**RE: Transmittal of Comments – Plum Creek Intervening Ownership Application (SG-12-00006)**

TO: Jeff Watson, Community Development Services  
FROM: Christina Wollman, Planner II *W*  
DATE: October 9, 2012  
SUBJECT: Plum Creek SG-12-00006

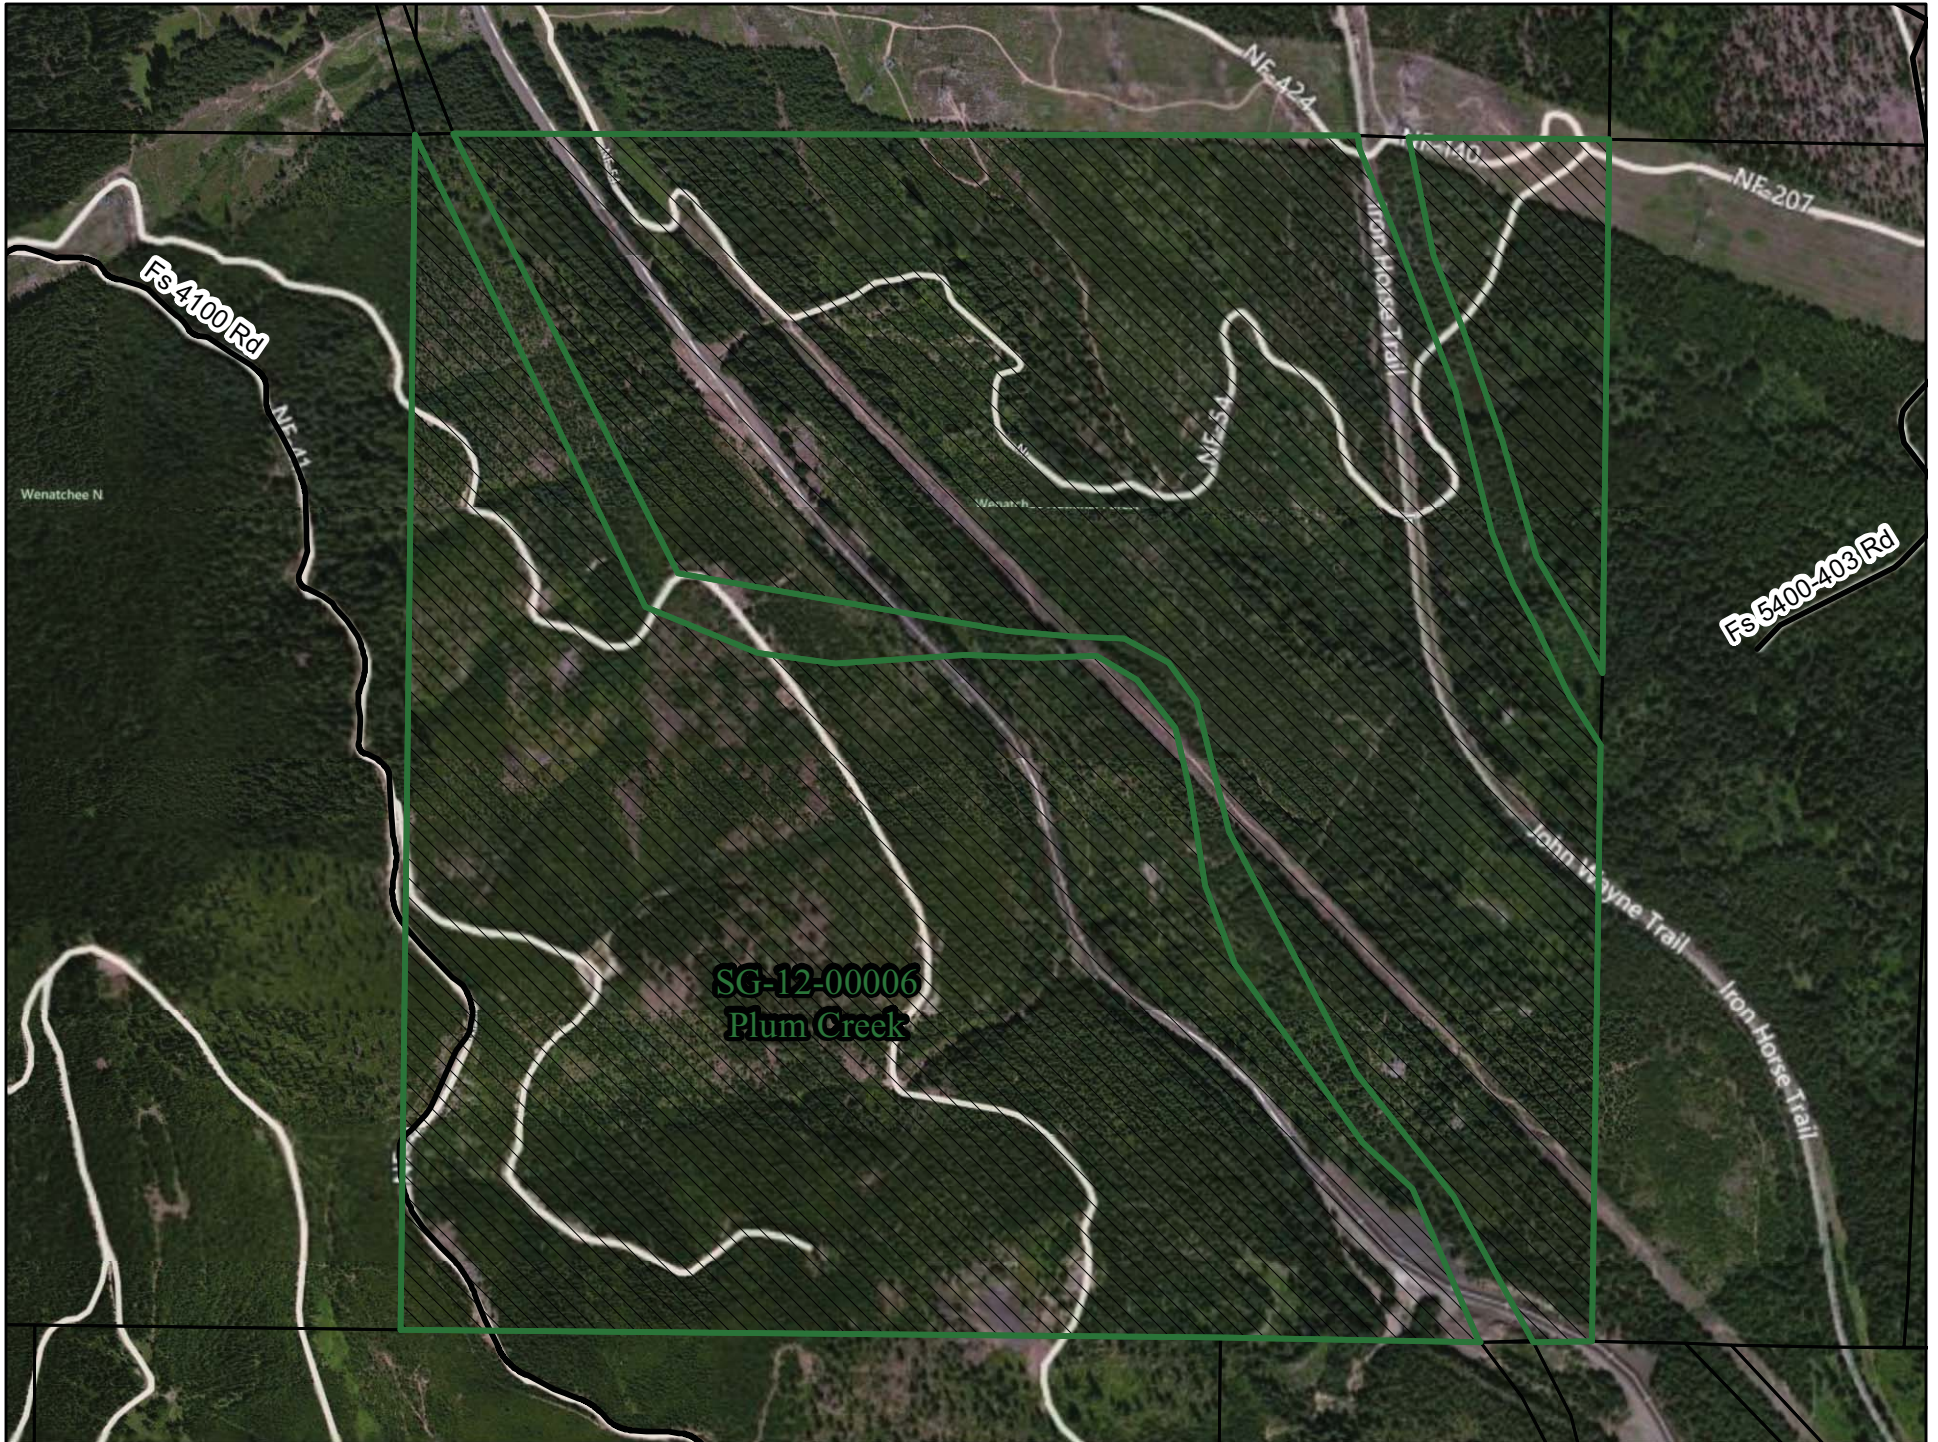
A couple of comments:1. Check list indicates no FS roads involved. FS RD 4100 is shown crossing a portion of the section. PC is a Cost Share owner in this road.

2. Is legal access to the new parcels required for this type action?
3. If so, no legal access for two two parcels is shown or indicated and the land prevents most access between the RR R/W and John Wayne trail ( flood area- other ownership ). How is this provided for ? Or is it?

The Commission's concern with a subdivision would be if the new property owner(s) plan to cross the Iron Horse Trail State Park they will need an easement to do so.

Currently, to my knowledge, Plum Creek does not have authorization to cross this portion of the trail shown in the attached aerial.

When Burlington Northern deeded the Iron Horse Trail property to WA Parks, they reserved access across it. Then BN assigned that to Plum Creek, so it appears that we do have legal access. I am attaching those documents for reference.
